Final Report - Corrections Required **Application No. DEPN-26-0063**

Description : Single Family Detached residential development located north of New Life Drive in the Flying Horse Master Plan

Document Filename : DP Creekridge at Flying Horse Filing No. 1 V2.pdf

CREEKRIDGE AT FLYING HORSE FILING NO. 1

CREEKRDIGE AT FLYING HORSE FILING NO. 1 DEVELOPMENT PLAN SITE DEVELOPMENT PLAN			
DESIGNED BY	JRH	SCALE	DATE 4/16/26
DRAWN BY	JRH	(H) 1"= 40'	SHEET 3 OF 24
CHECKED BY	(V)	1"= N/A	JOB NO. 1171.78

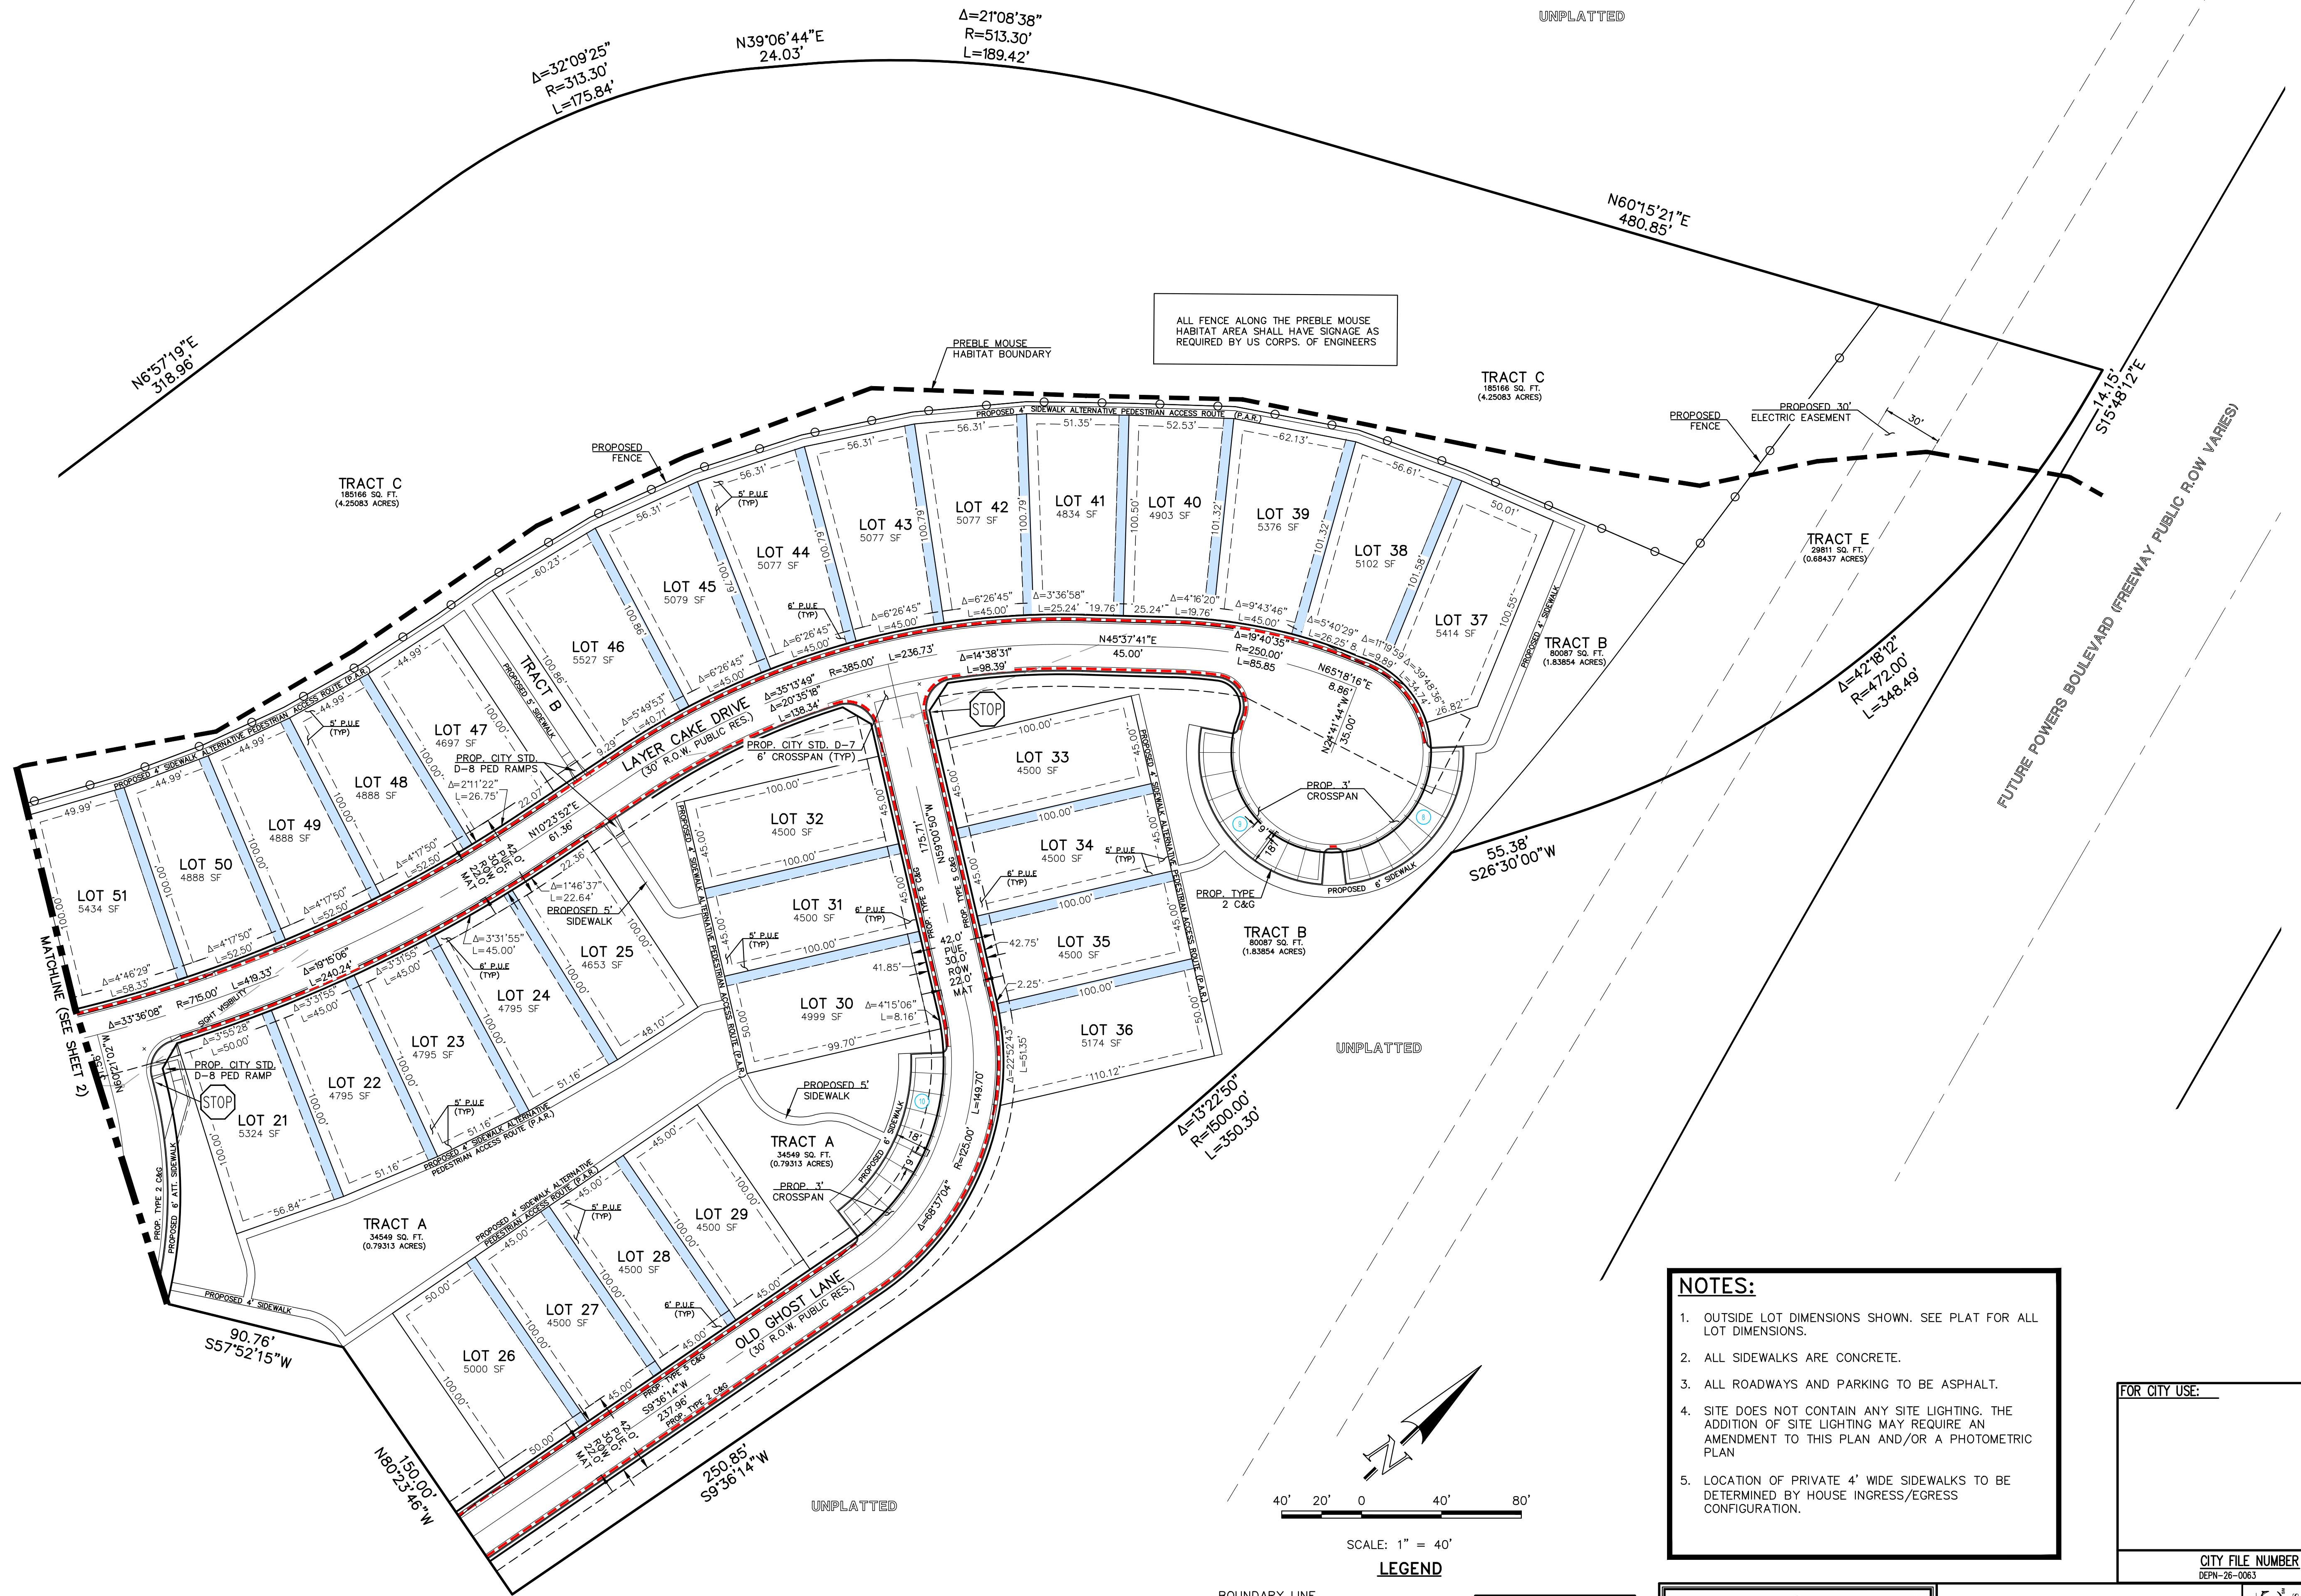
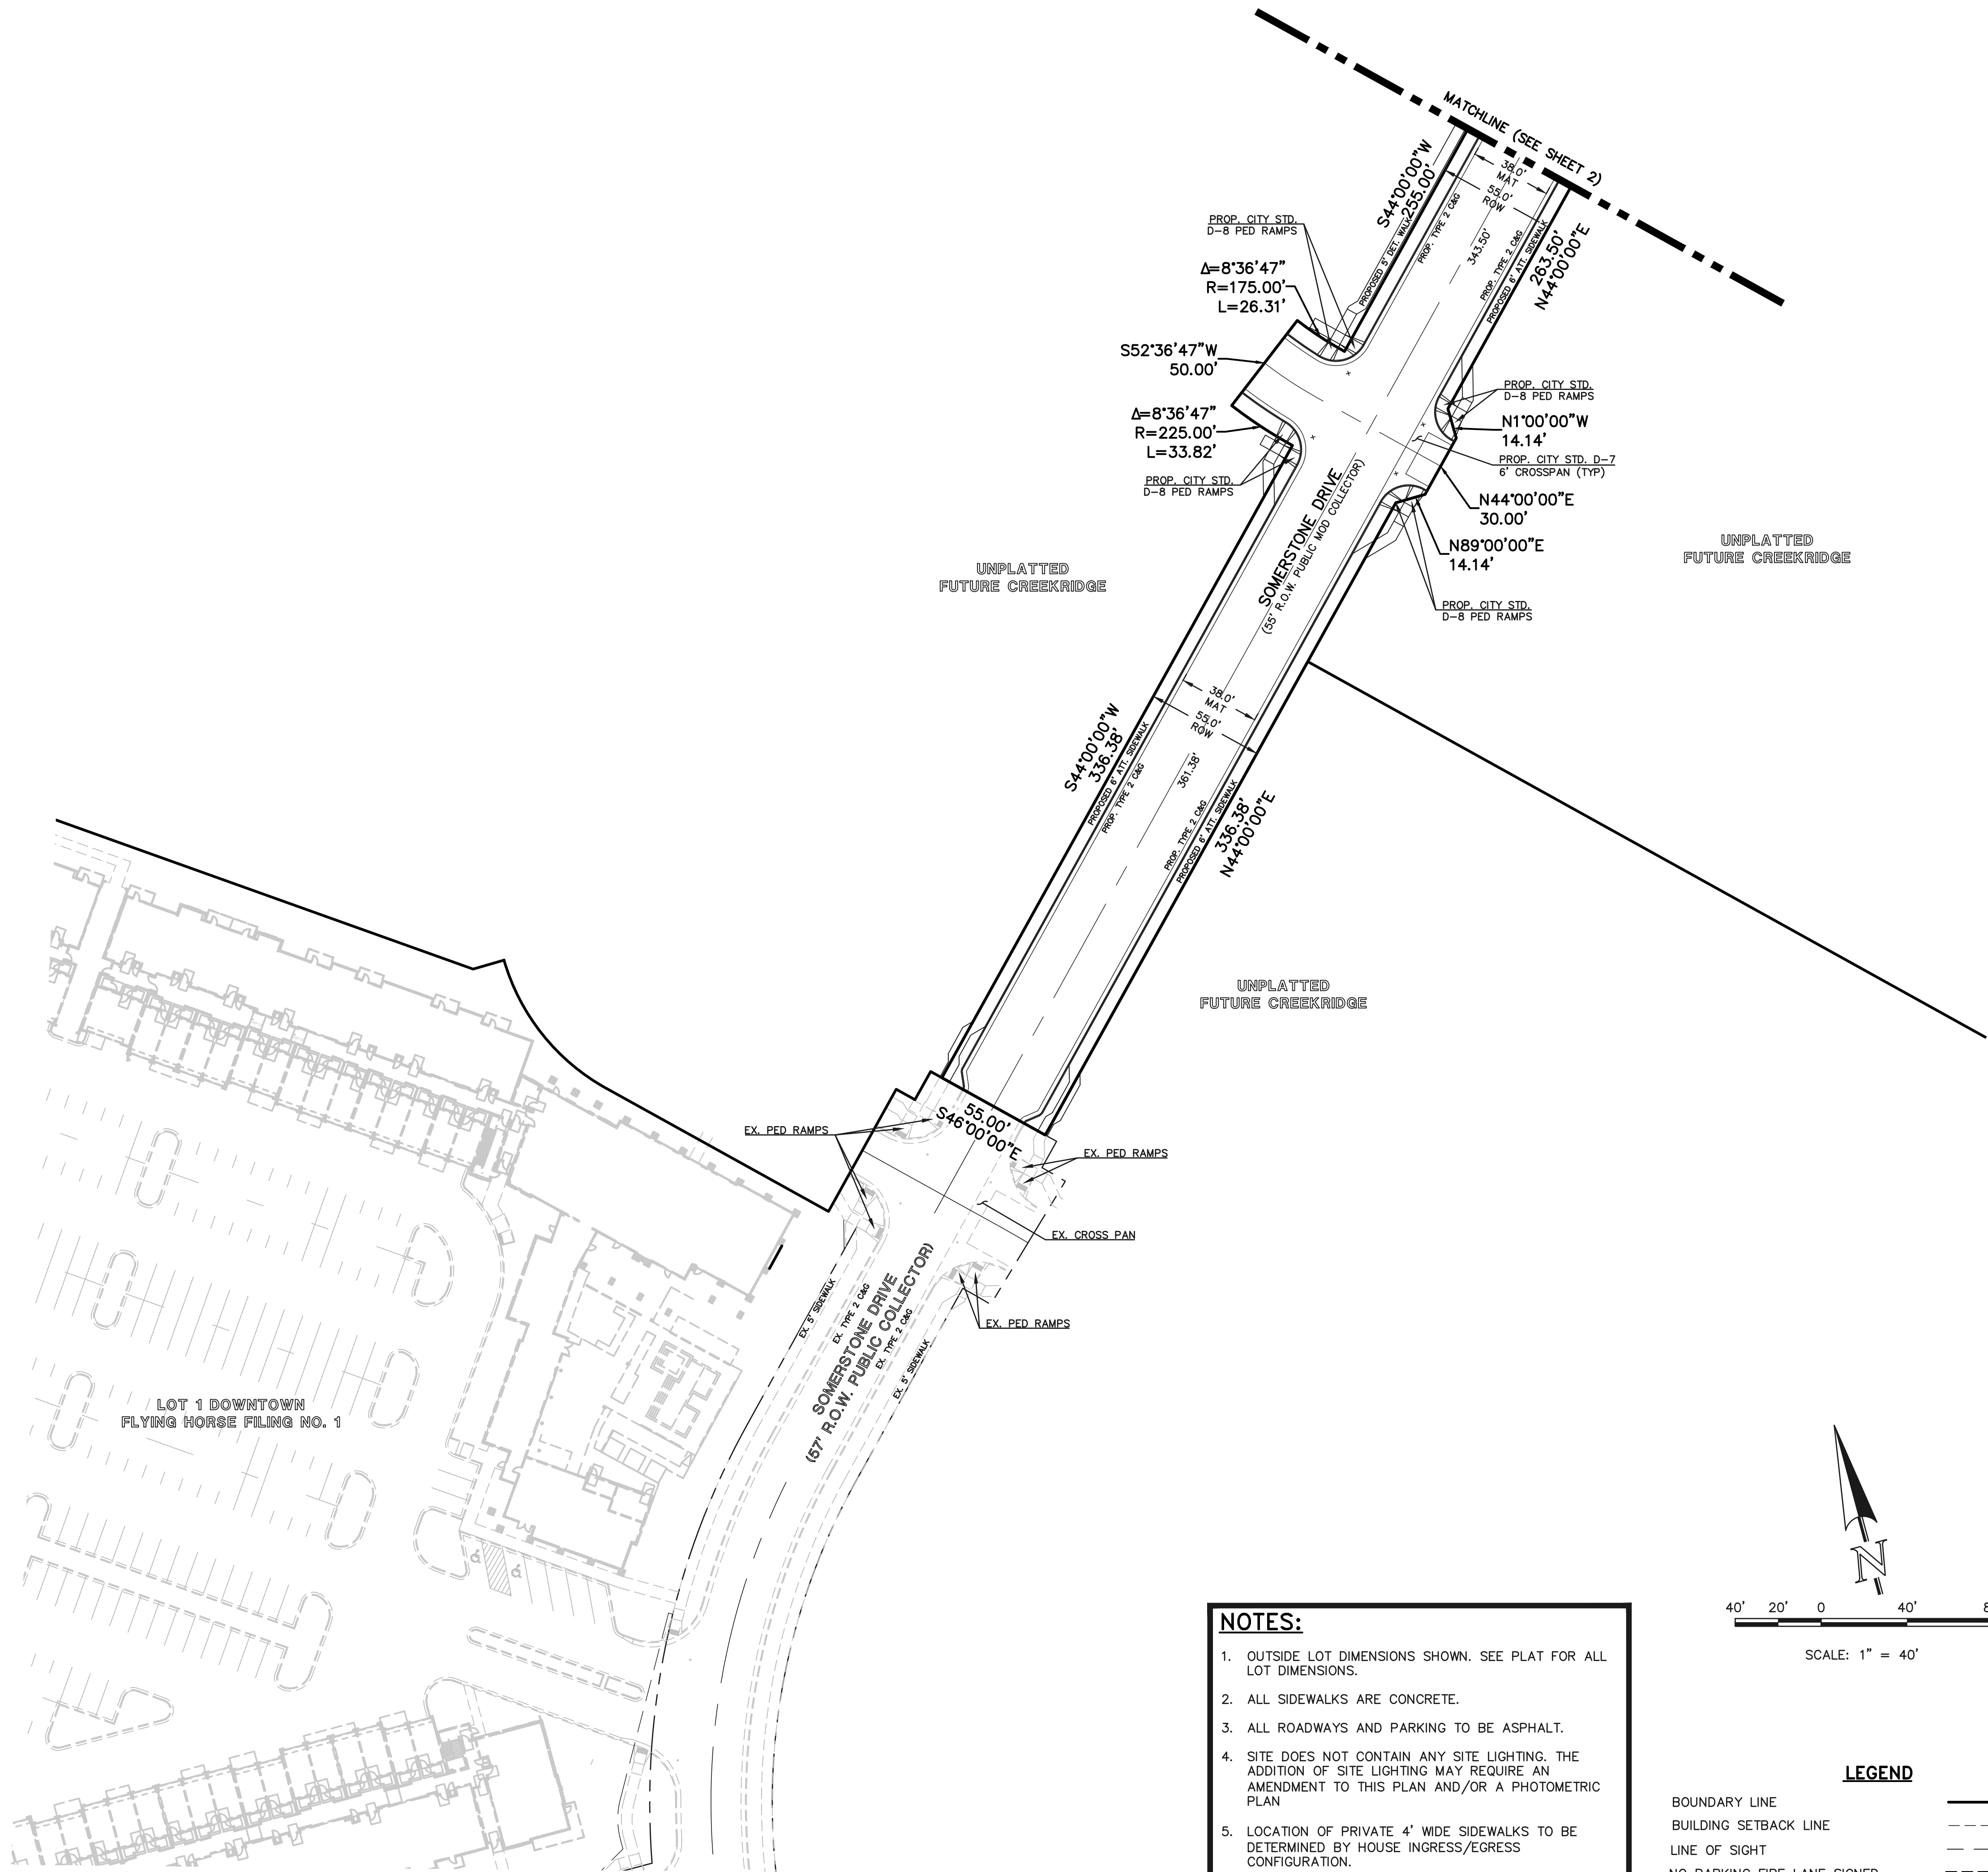
97	1	Caroline Miller : Planning	Additional Park Notes may be added upon next review.
101	1	Allison Stocker : Planning	See follow-up on ADA stalls.
109	2	Allison Stocker : Planning	will the vinyl fencing be on top of these retaining walls?
99	3	Allison Stocker : Planning	Lot 43
92	23	Gregory Stachon : Planning	don't see where the retaining walls are proposed. please label on landscape and grading plan if there are any proposed walls along with their max. height. Remove details if not used.
100	23	Allison Stocker : Planning	I am still having difficulty locating the proposed retaining wall and vinyl fence locations. Please make sure they are called out on the plan sheets
90	24	Gregory Stachon : Planning	The following notes need to be included with the landscape typical (COS Landscape Manual Appendix C) "All Trees located within City ROW are to be chosen from the current Forestry City Approved Street Tree List." "All required Compact Lot trees shall be installed by the developer/builder. Long term maintenance responsibility and irrigation for trees will be provided by _____ " (applicant to provide) "All required Compact Lot trees shall have an automatic irrigation system (drip/sod irrigation/etc.) which provides watering at time of planting."
